Date 17 July 2015

RE: S6/2015/1342/PP - Land to the North East of King George V playing Fields

In response to the proposed outline application for the above development site, based on the FRA carried out by Lands Improvement reference KGV-FRA-2015-001 dated June 2015, we have no objections to the principle of the development on flood risk grounds.

Surface Water  
Drainage Strategy  
Option 1 - Outfall Proposals

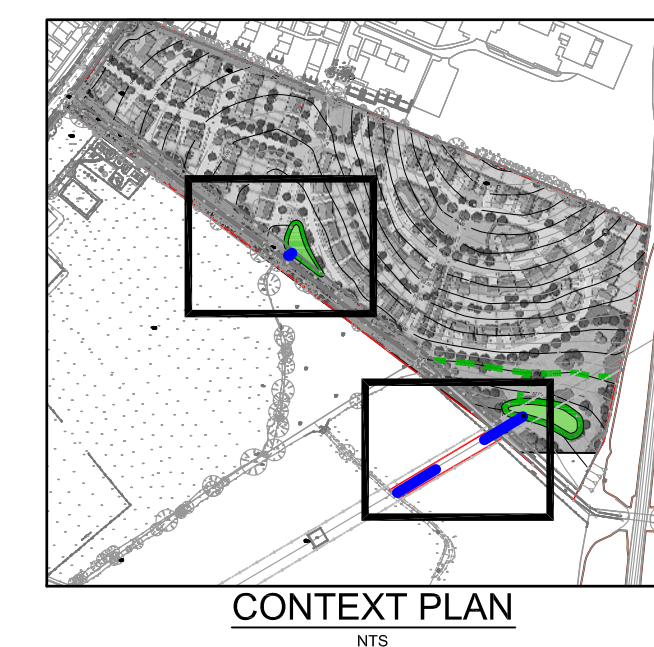
4. Implementing appropriate SuDS measures giving priority to above ground measures such as ponds and swales
5. Discharge surface water to the existing ordinary watercourse along the southern boundary of the development site
